An
Bord
Pleanála

Inspector's Report ABP-318223-23

Whether the construction of a conservatory, 3 no. structures and an access track is or is not development and is or is not exempted development.

Lettergesh East, Renvyle, Co. Galway

Manufacturers dimensioned drawing of new conservatory

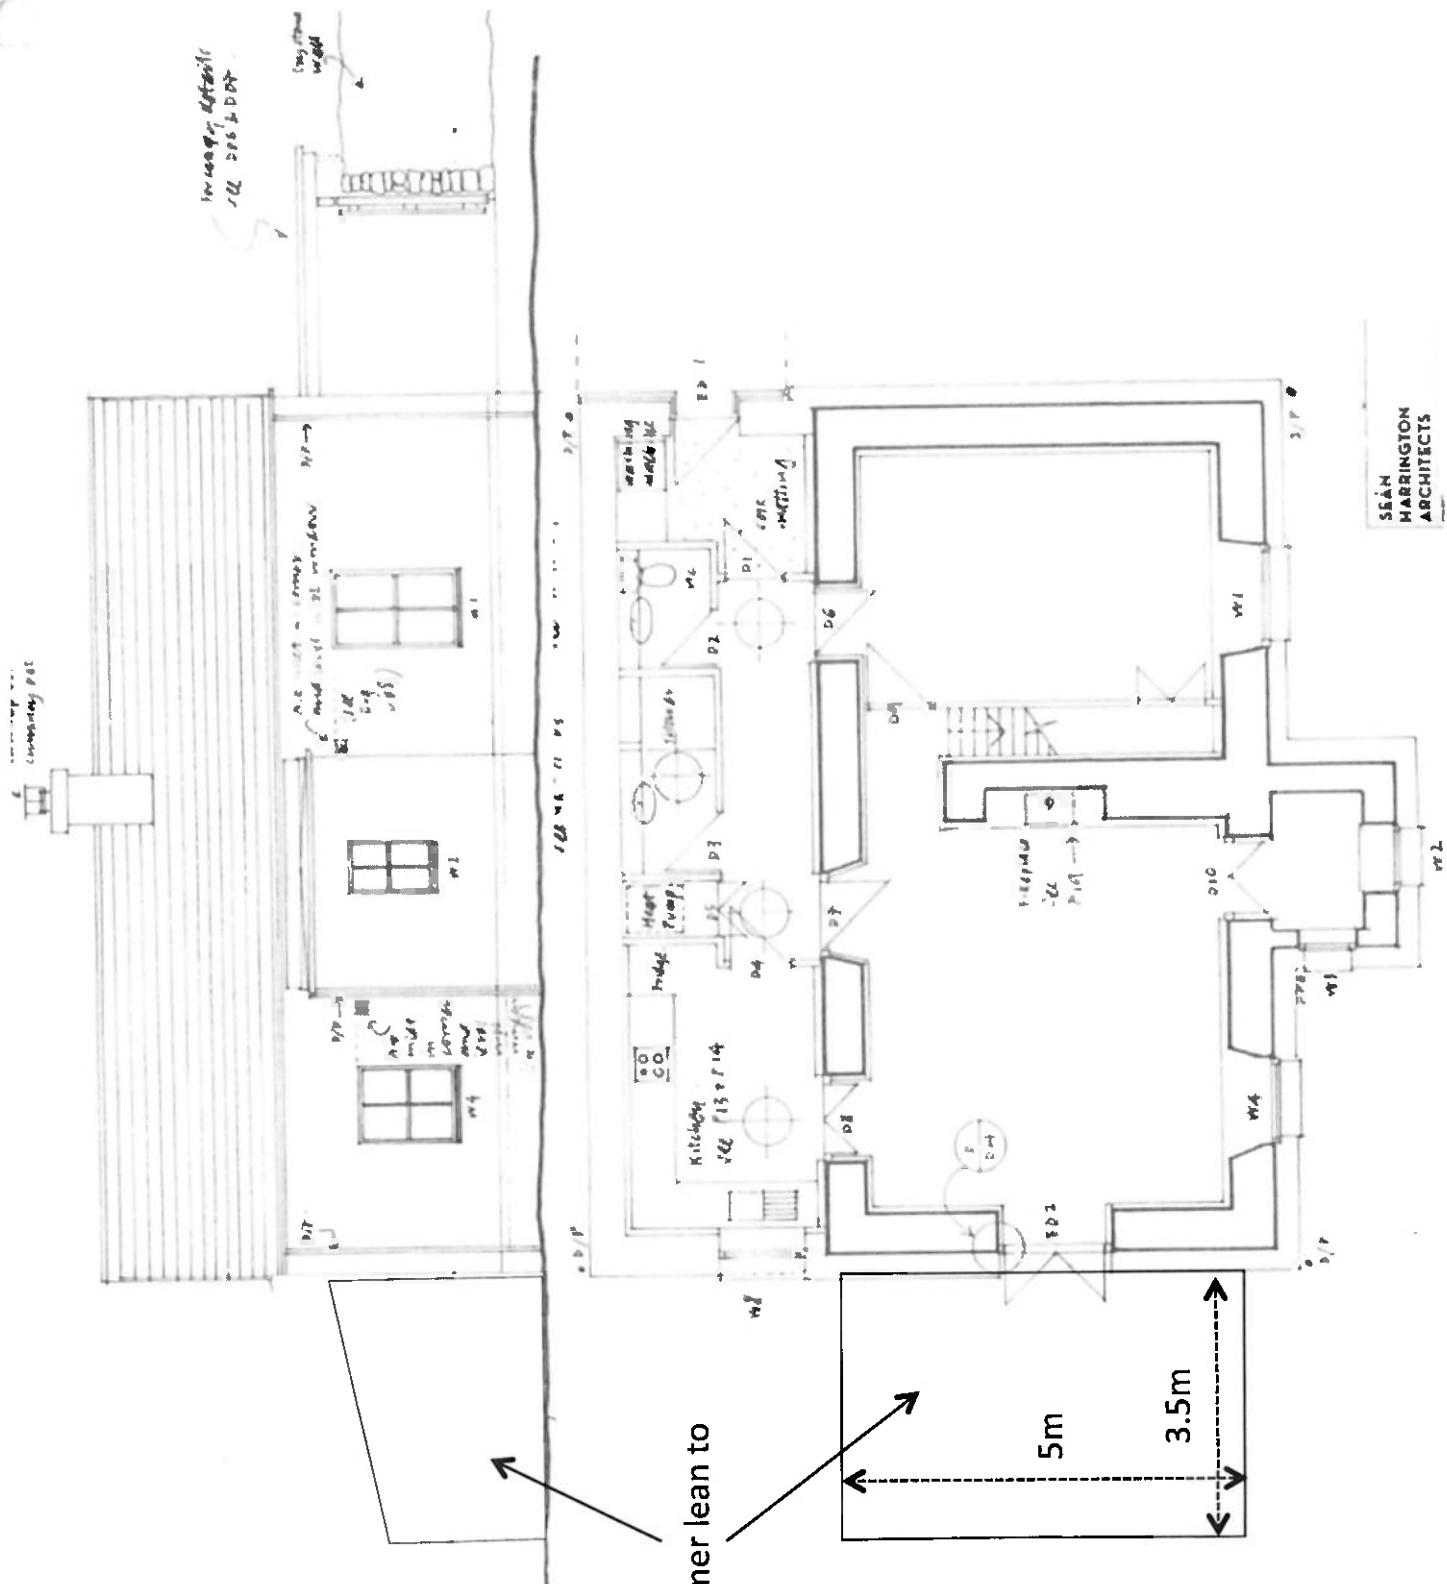
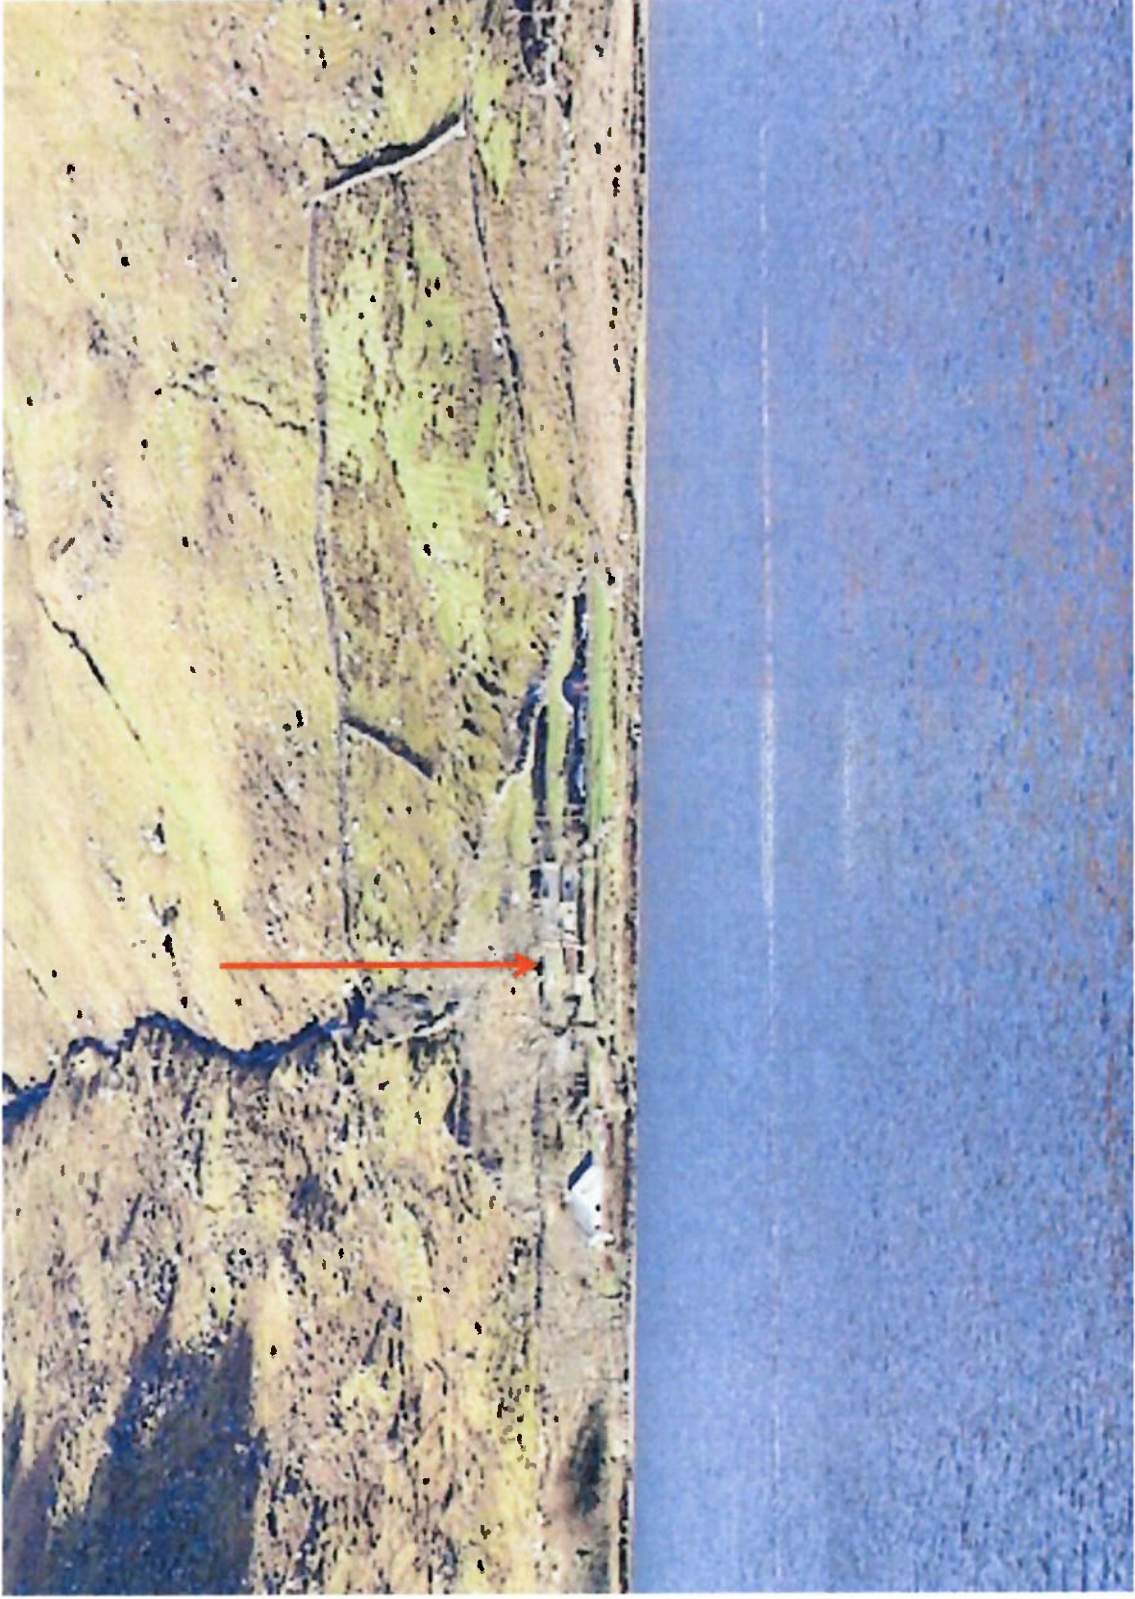
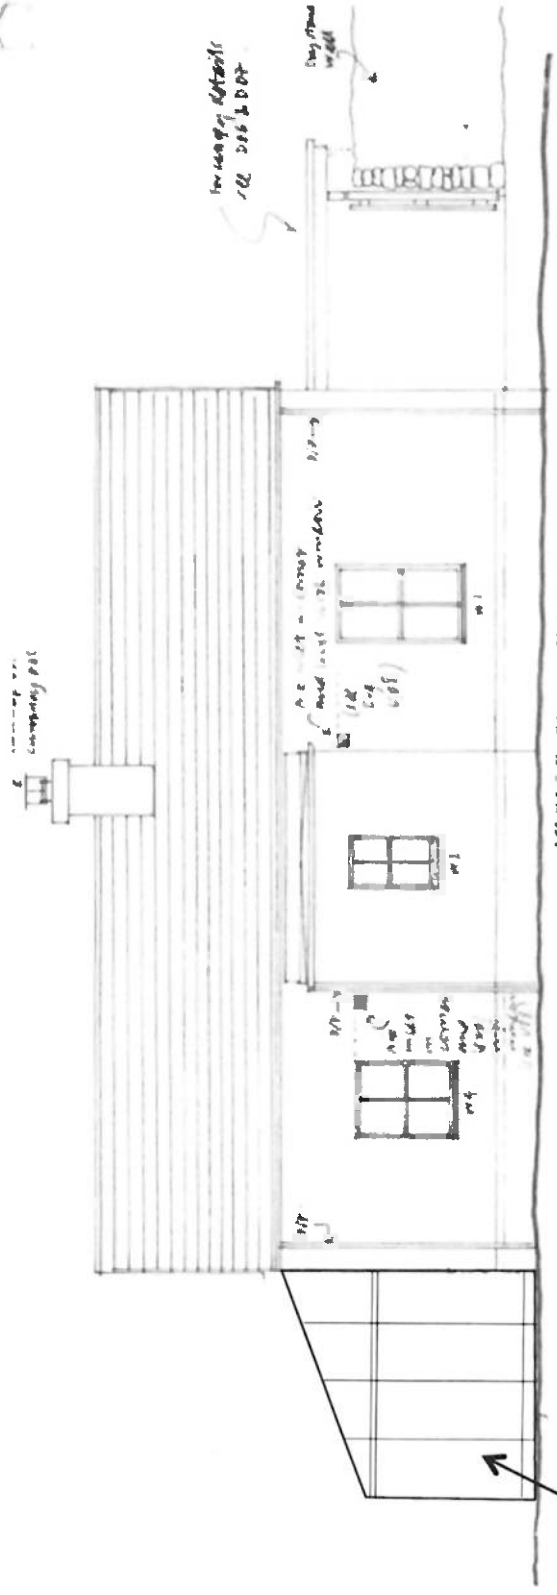
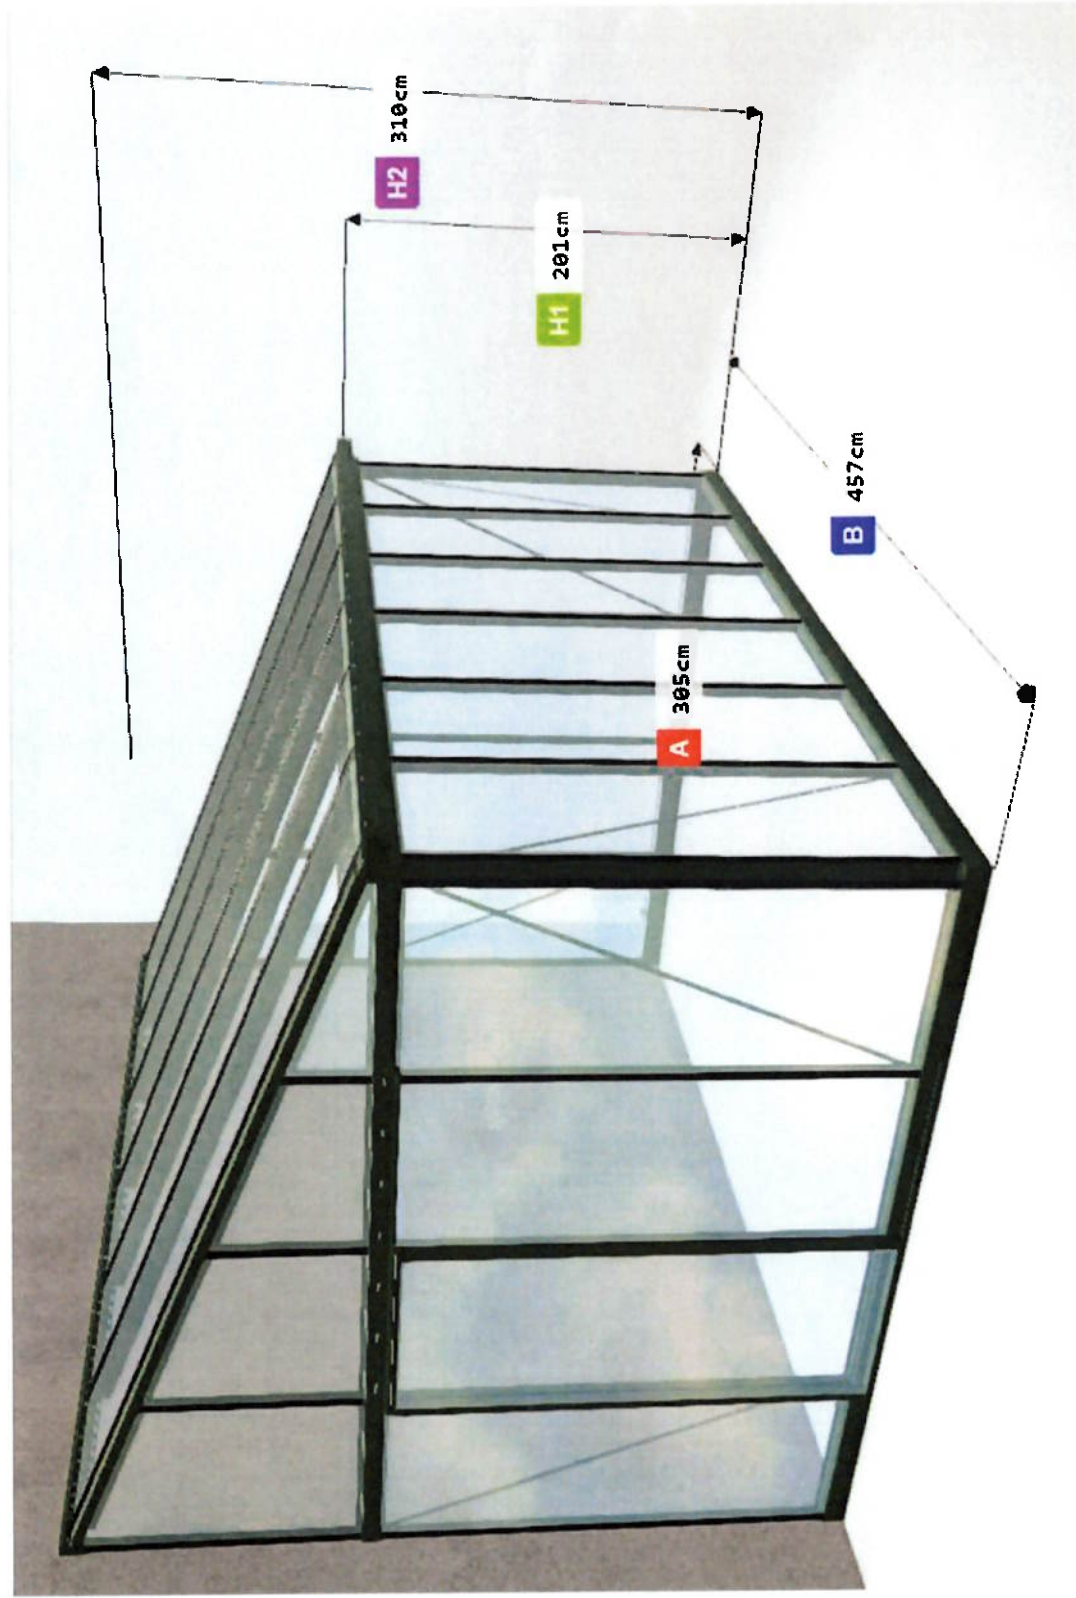
8.4.2. **Conservatory** – the conservatory attached to the side/southern elevation of the dwelling is stated as replacing a previous ‘lean-to’ type structure (photographs and a floor plan of same are provided in referrer’s submission). The floor plan indicates dimensions of 4.5 metres (L) x 3 metres (W), giving a floor area of c. 13.5 sqm. The structure has a maximum height of 3.1 metres. Class 1, Part 1, Schedule 2 of the Planning and Development Regulations 2001, as amended, provides that development within the curtilage of a house comprising the extension of a house, by the construction or erection of an extension (including a conservatory) to the rear of the house or by the conversion for use as part of the house of any garage, store, shed or other similar structure attached to the rear or to the side of the house⁶. As the conservatory replaces an lean-to structure I consider that it falls within the description of ‘the conversion for use as part of the house of any garage, store, shed or other similar structure attached to the rear or to the side of the house’. To avail of the exemption under Class 1, the proposal must comply with the conditions and limitations in Colum 2, listed 1 – 7. I note that the conservatory complies with the applicable conditions and limitations and in this regard I note the following;

- The conservatory is single storey.
- The floor area of the conservatory and the existing rear annex does not exceed 40 sqm.
- The height of the conservatory does not exceed the rear wall of the house, and the height of the highest part of the roof of the conservatory does not exceed the highest part of the house.

- The conservatory is located to the side of the house and does not affect private open space to the rear of the house.
- The conservatory is situated in excess of 1 metre from the opposing site boundary.
- The roof of the conservatory is not used as a balcony or roof garden.

I consider that the conservatory comes within the scope of the exempted development provisions of Class 1, Part 1, Schedule 2 of the Planning and Development Regulations, 2001, as amended and **is exempted development**.
